Please ask for: Nicola Moore
Email: nicola.moore@arun.gov.uk
Telephone: Ext 37944
Our Ref: WA/106/21/CLP
Your Ref:
Date: 16th November 2021

Lawful Development Certificate for a Proposed Use or Development

Development: Lawful development certificate for a proposed half acre extension to the south wall of existing greenhouse.
Location: Crosslands Nursery Barnham Lane Walberton BN18 0AX

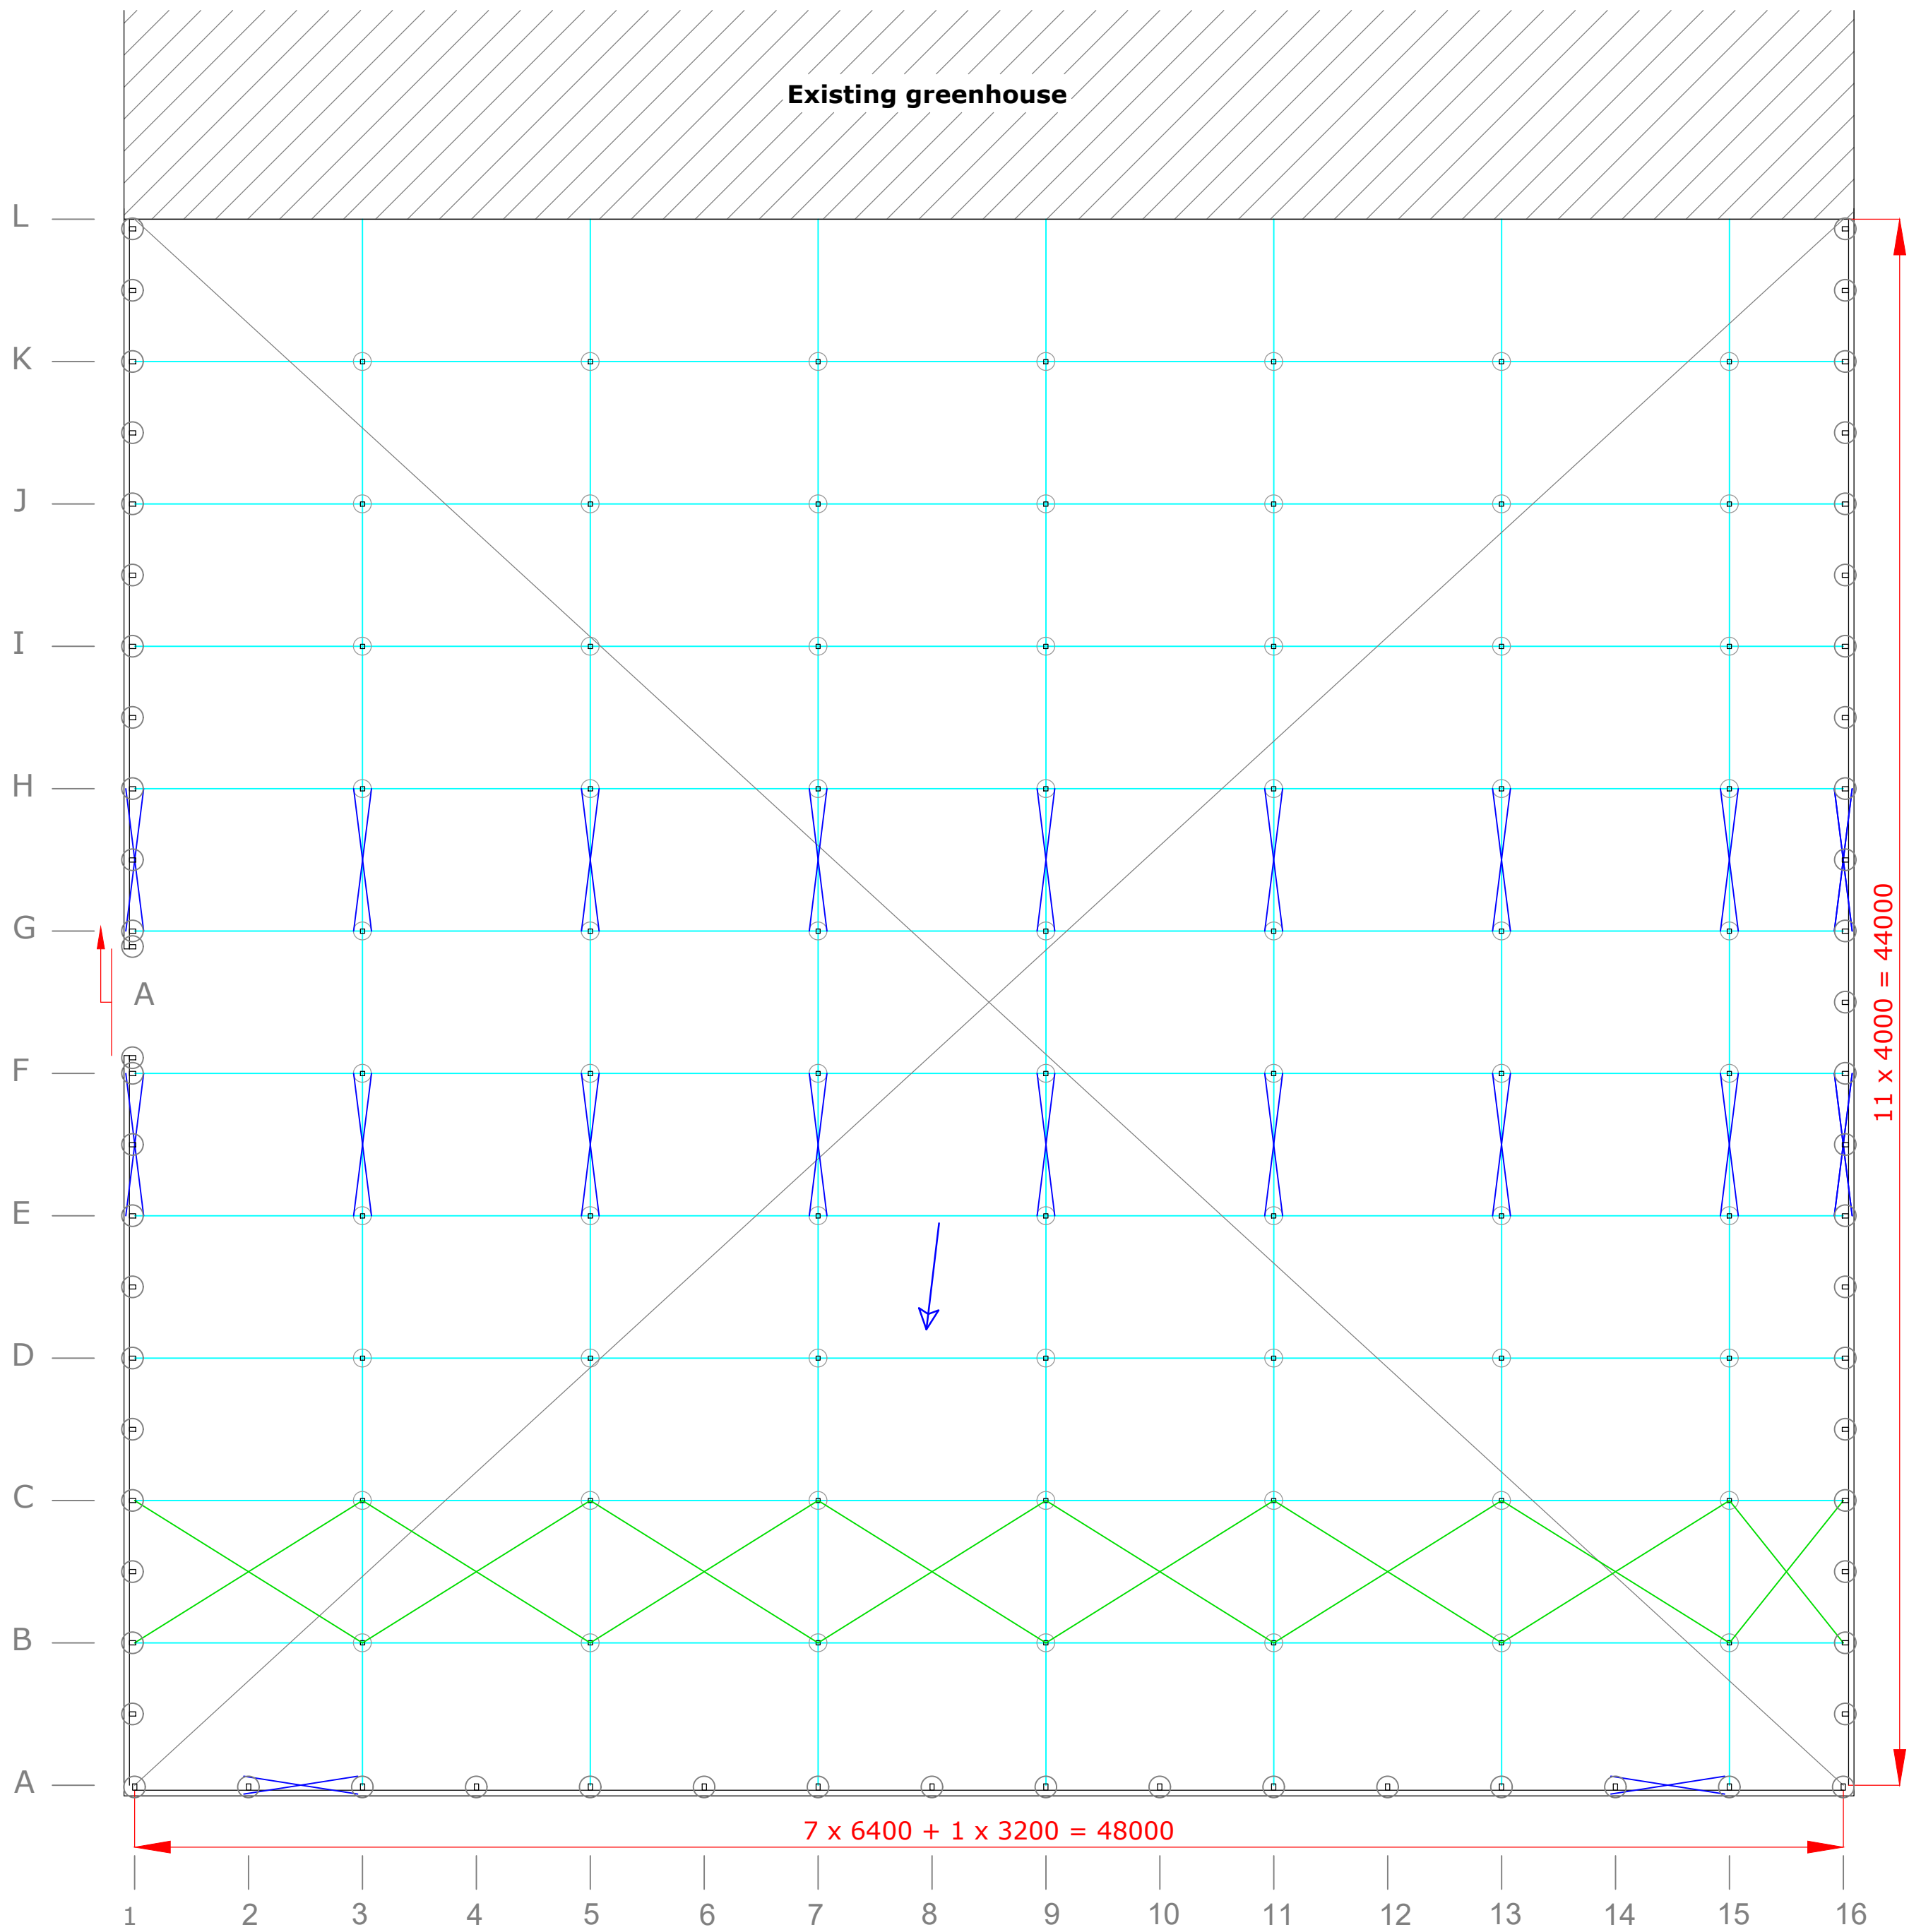
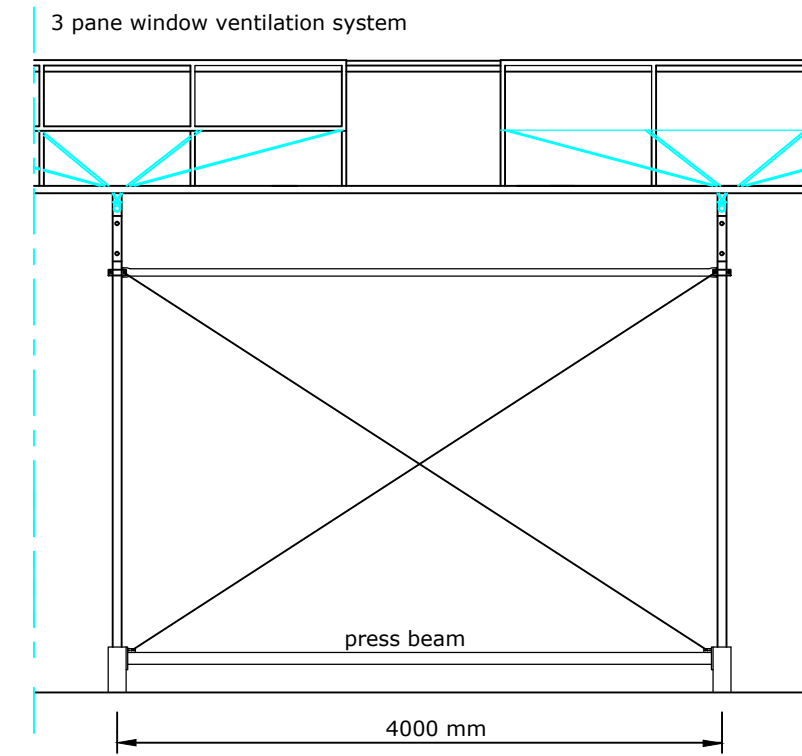
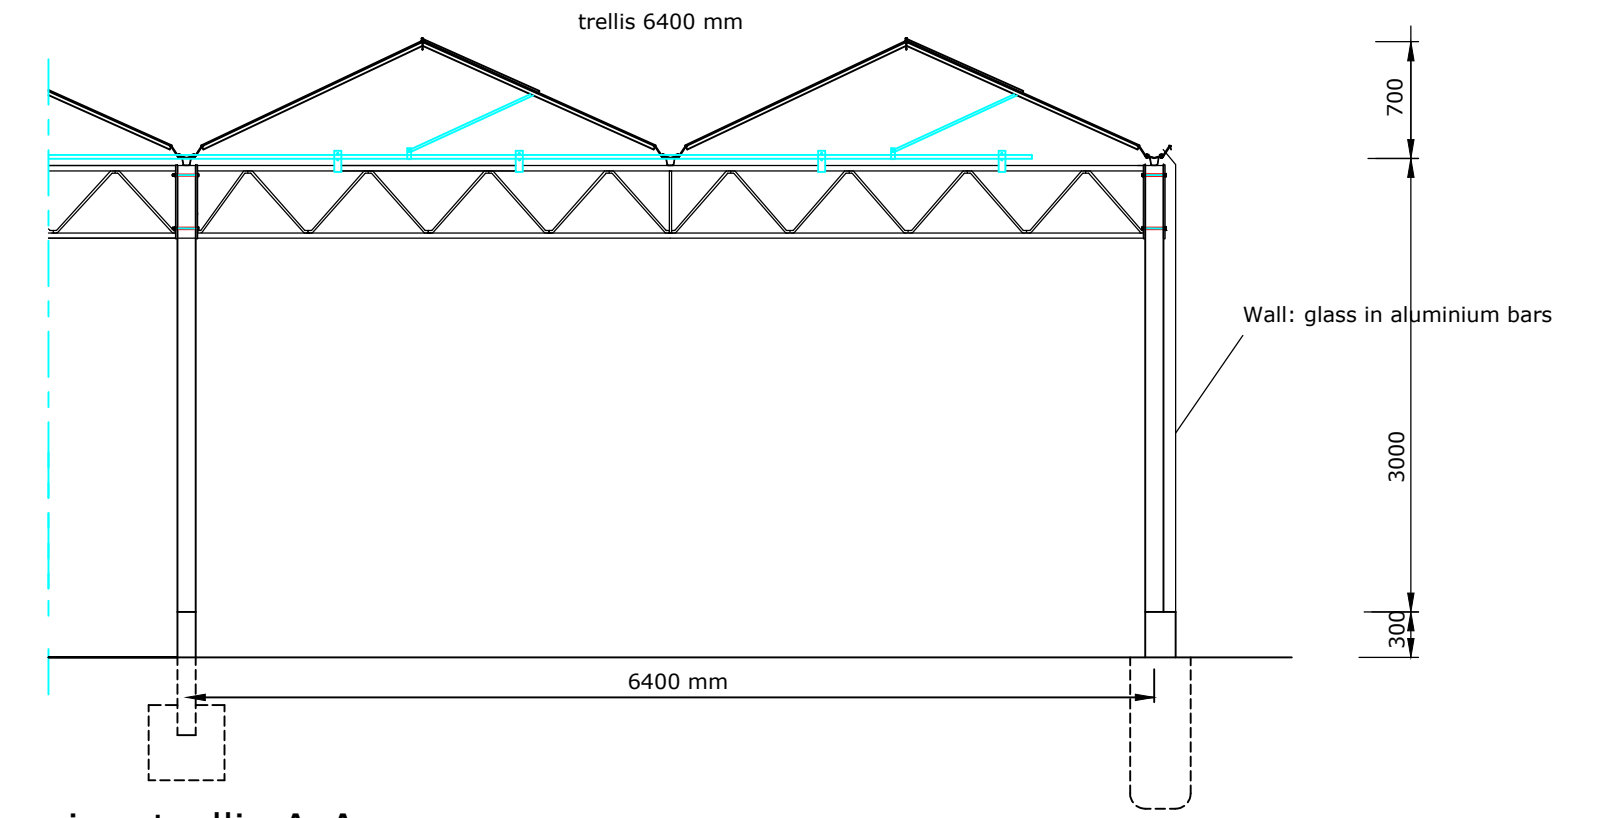
The submitted floor plans and elevations do not scale correctly, please re submit at a scale of 1:100 or 1:50. The plans should be clearly labelled existing and proposed.

Subject: Groundplan google			
Drawn by: Fedor Kerstiens		Client / Project: Crosslands Nursery BN18 OAX Arundel (West Sussex) United Kingdom	
Date: 19-03-2021			
Revised: /		Surface: 2.112.00 m²	
	Unit: mm	Scale: 1:150	Number of sheets: 1
	iso-129		Sheet number: 1
		Format: A1	Drawing nr: 1050G-01

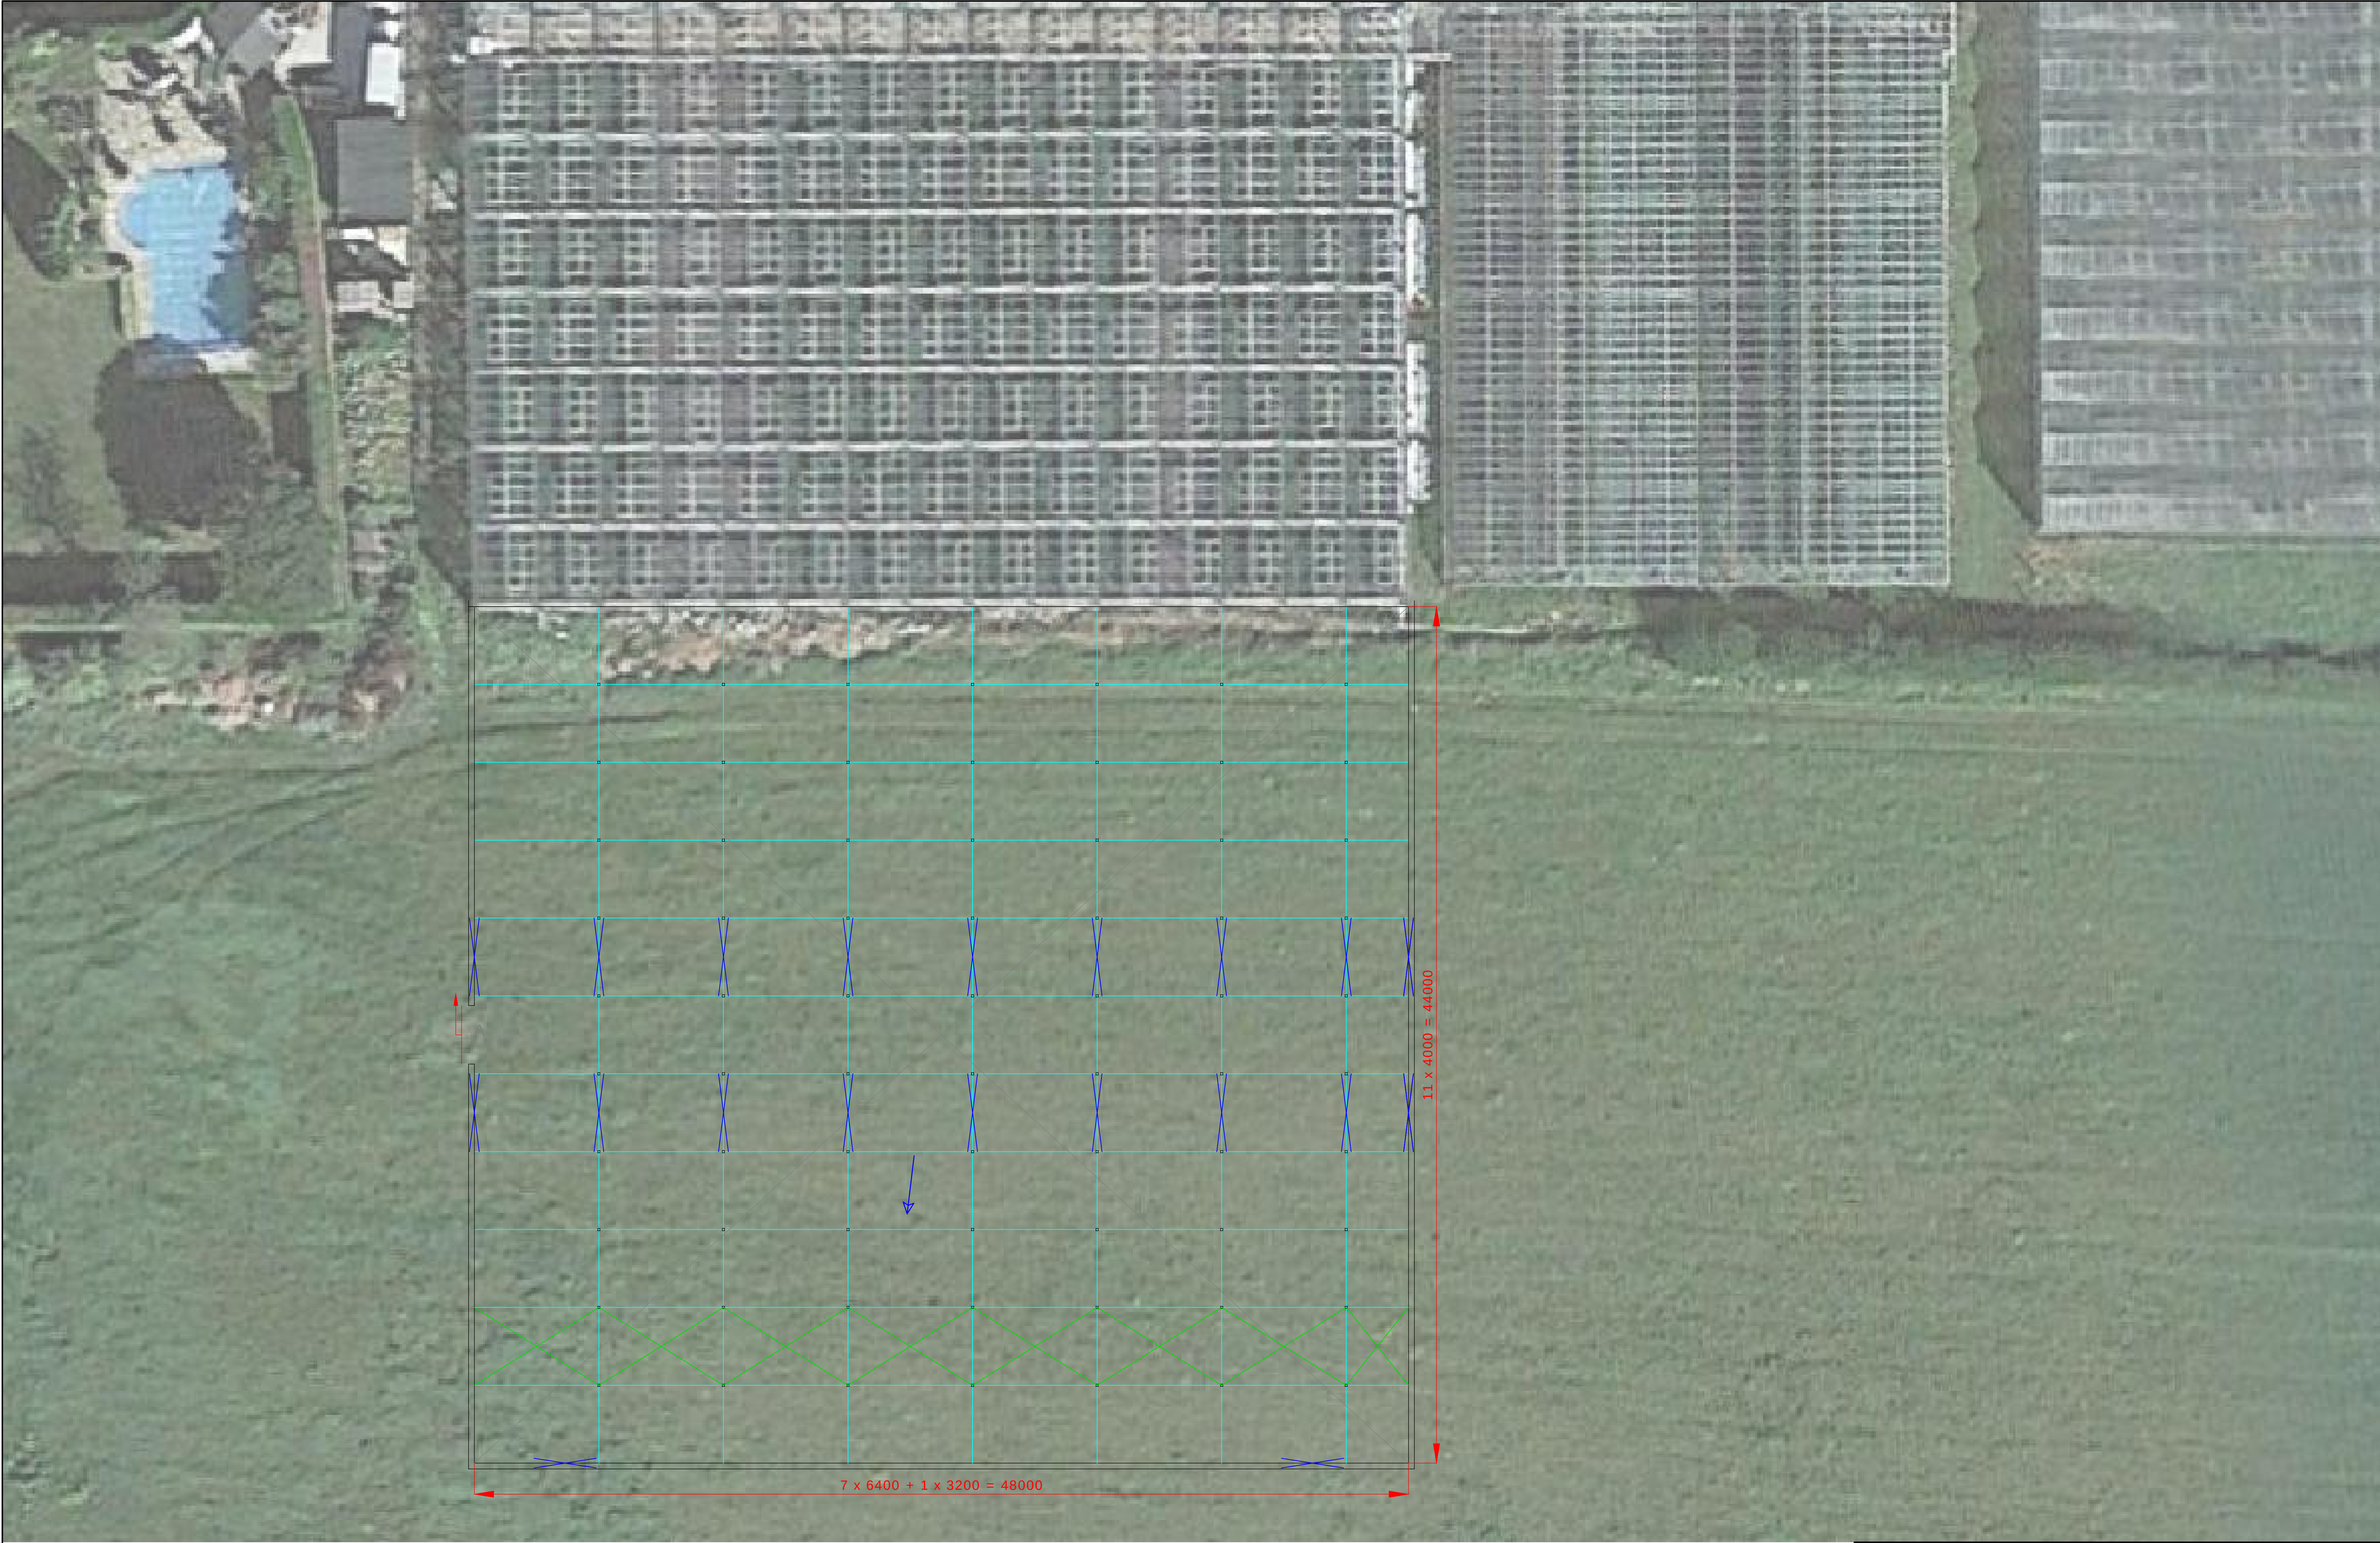
Please amend the Location plan to show the direction of North and re submit. Further details of what must be included on the plan can be found in the Validation Requirements List.
